SURFACE WATER DRAINAGE – SUPPLEMENTARY REPORT LAND TO THE REAR OF SUNNYSIDE BARN AND FLINT BARN, BARNHAM

For Manorwood Ltd

Report Number: YE4281, Date: May 2020

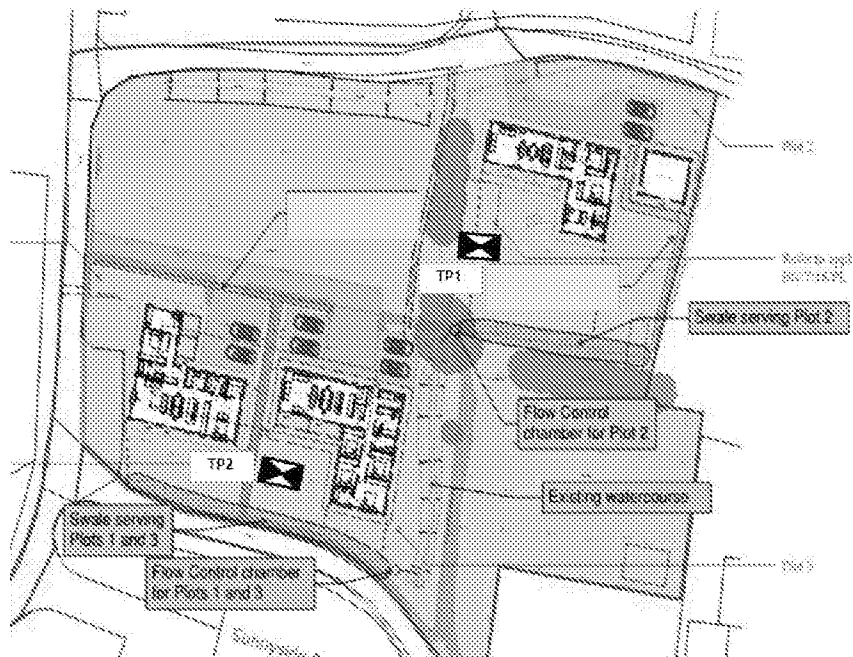
1. The groundwater level identified as part of the infiltration testing is unclear. The results state that each pit "filled 60cm within 20mins" from a starting point of 0.9mbgl and 0.7mbgl. On this basis we have read the results as peaking at 0.1mbgl in TP2. (Rather than both pits stabilising at 0.6mbgl). If this is the case the swales will require impermeable liners to avoid groundwater ingress, this will require the design to account for buoyancy. If the groundwater is in fact at 0.6mbgl then the applicant is advised to approach this department to discuss any further required monitoring and/or design options.

It is agreed that the data as presented could have been made more clear. During the excavation of the trial pit water ingress was noted at 0.9m bgl and was reported (verbally) to be perched groundwater which did not prevent the excavation from continuing to the target depth of 2.0m bgl. Once the excavation was complete water filled the excavation by 60cm (to 1.4mbgl) within 20mins. It is our contention that the design groundwater level is at 1.4m bgl (at TP1 and at TP2).

The Trial Pits were excavated in the positions shown below (not provided in the previous report). The ground levels at these locations are approx. 9.3m AOD for TP1 and approx. 9.1m AOD for TP2. Therefore, it may be stated that the groundwater level in TP1 has been measured at approx. 7.9m AOD at TP1 and at 7.7m AOD at TP2.

This would make sense as the watercourse which passes through the site has a bed level at between 8.2m AOD and 7.95m AOD. The lowest level being at the culvert which drains the site southwards. It would make sense that this watercourse prevents the groundwater from rising to the ground levels found across the site.

SHE-0051-1000-0700-1000

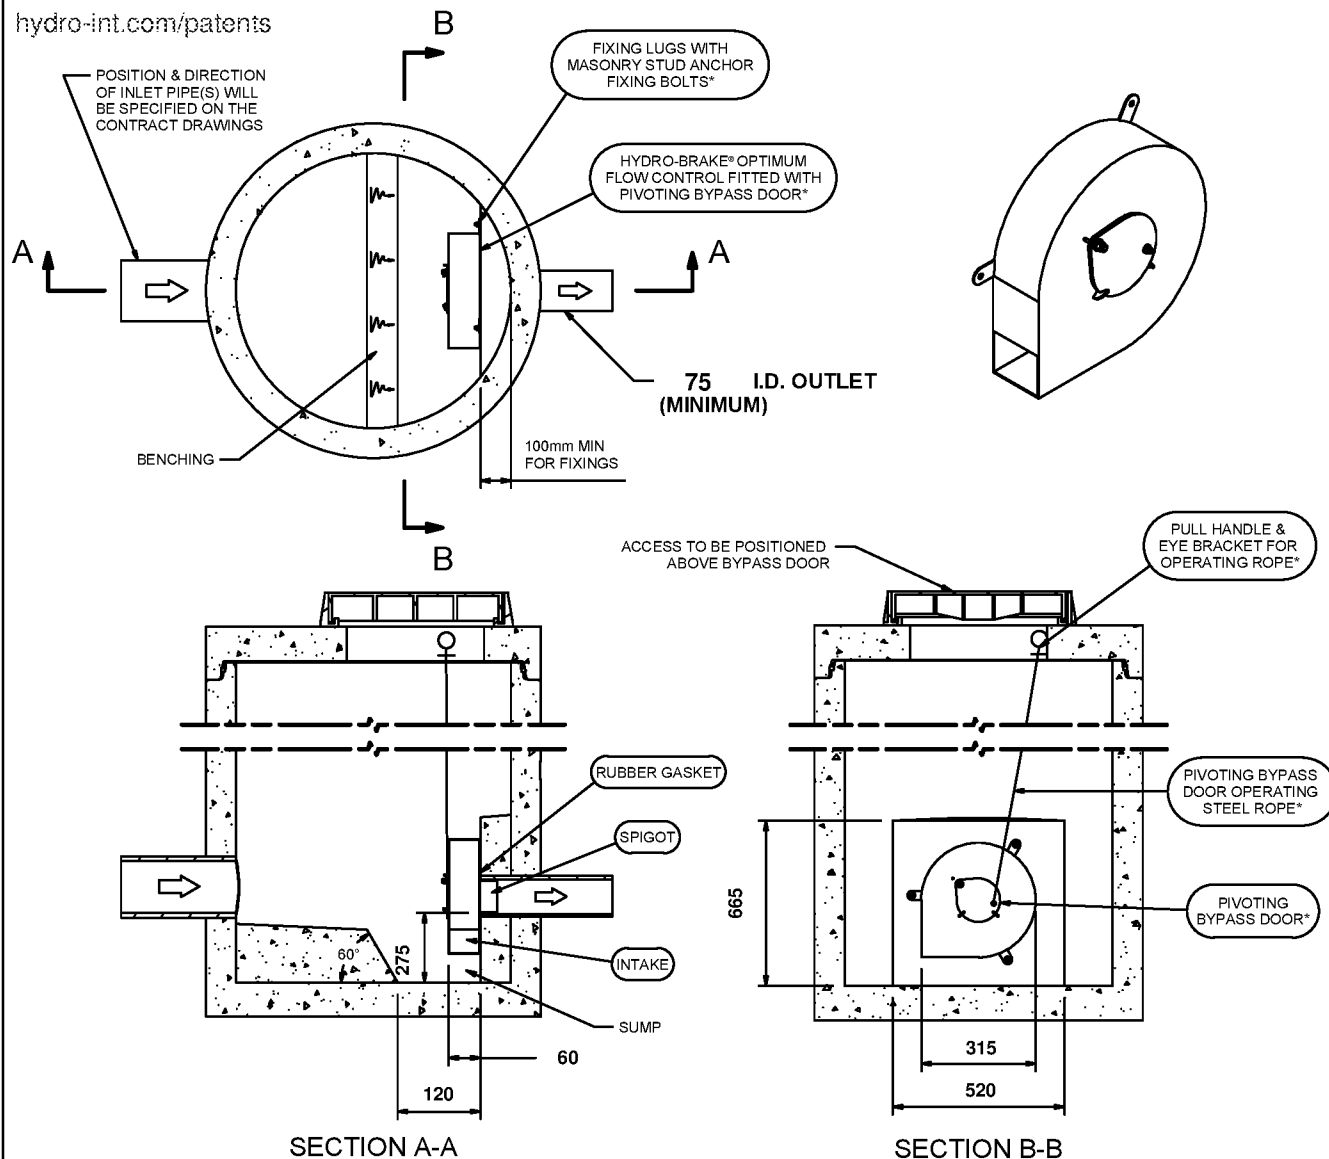
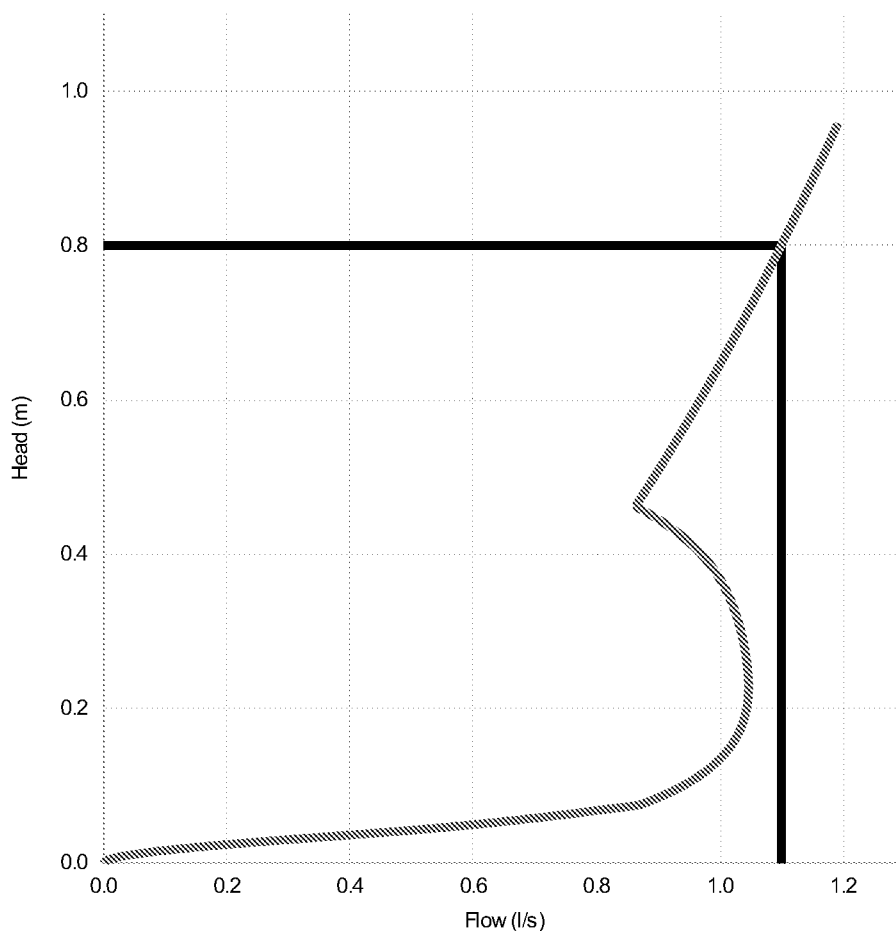
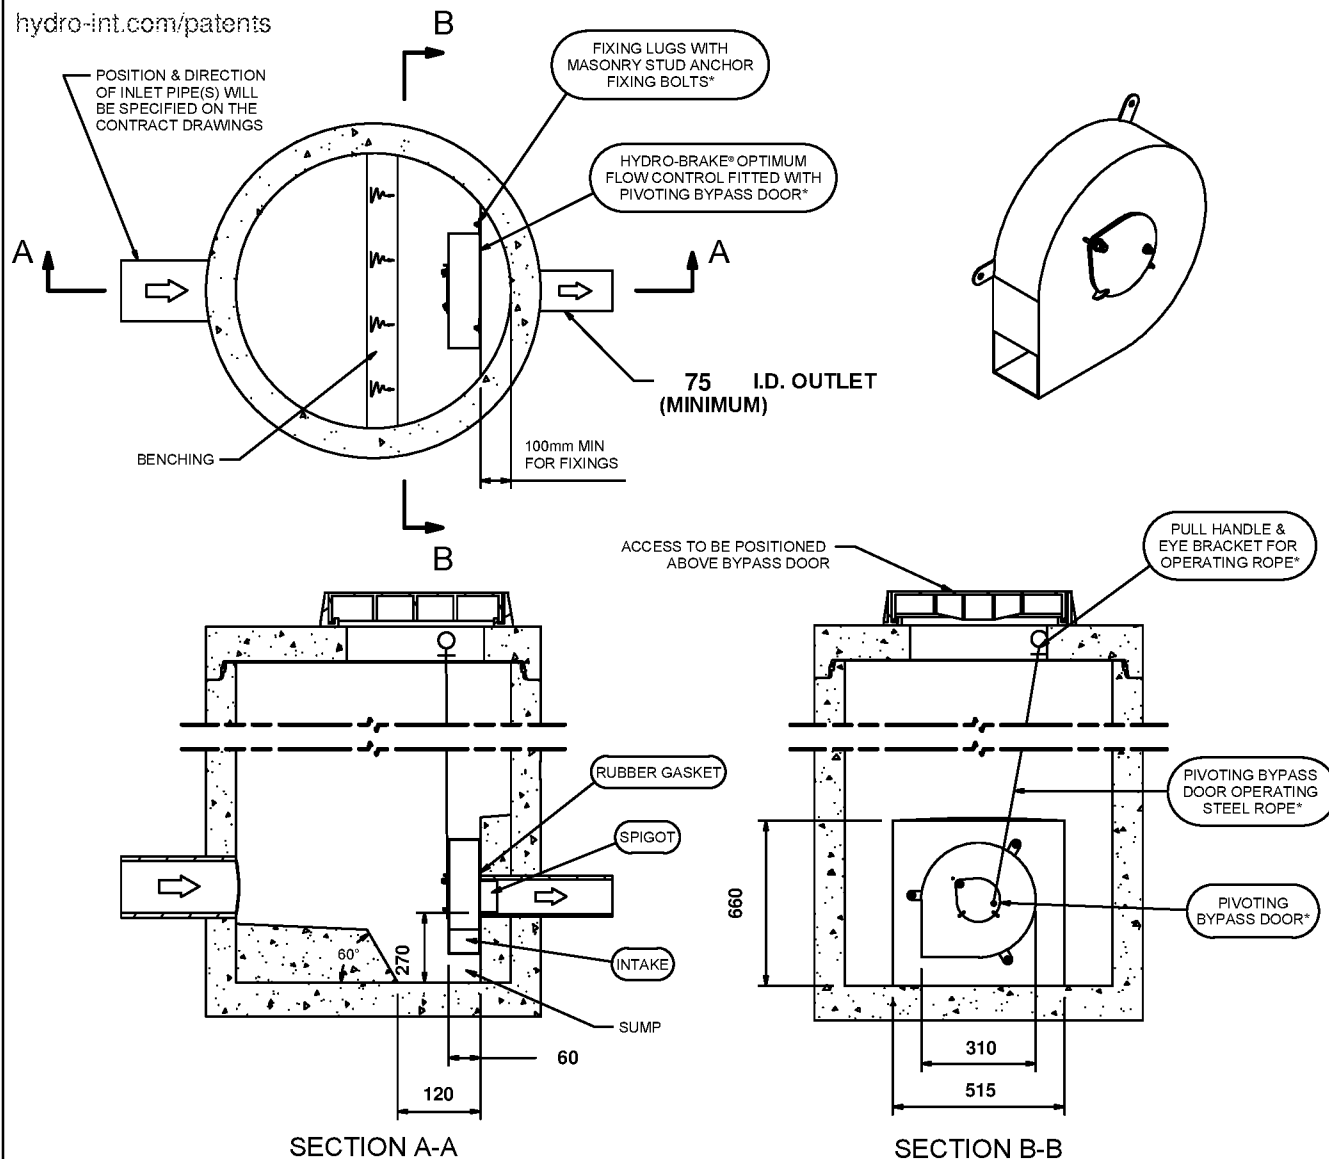
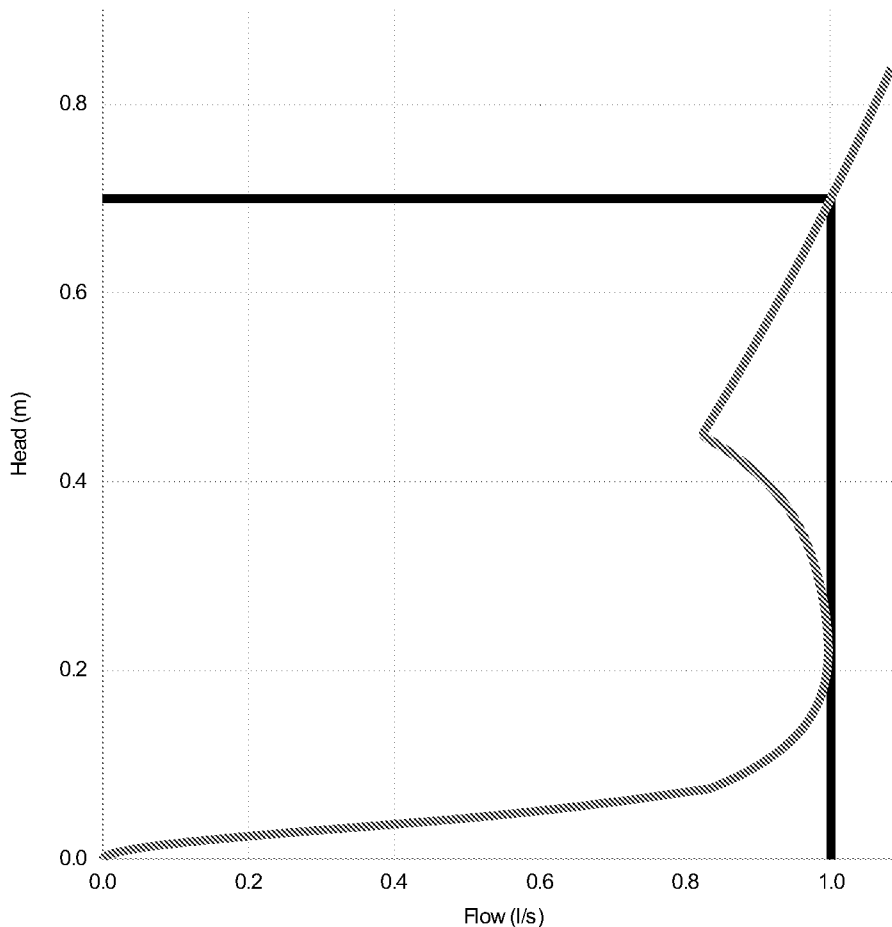
We do not accept orifices of less than 50mm as control devices due to the risk of blockage causing flooding upstream. On this basis the calculations will likely change with the inclusion of alternative flow control devices.

As an alternative, hydrobrakes have been incorporated into the detailed design which provide the necessary control to the discharge rates whilst maintaining an orifice size of at least 50mm.

The flow control device proposed to limit flows from the Plot 1 & Plot 3 swale is a Hydrobrake with a Design Flow of 1.1 l/s at a Design Head of 0.8m (it is noted that the specified Hydrobrake has a 52mm orifice, it had been recommended that orifices no smaller than 50mm are suitable).

The flow control device proposed to limit flows from the Plot 2 swale is a Hydrobrake with a Design Flow of 1.0 l/s at a Design Head of 0.7m (it is noted that the specified Hydrobrake has a 51mm orifice, it had been recommended that orifices no smaller than 50mm are suitable).
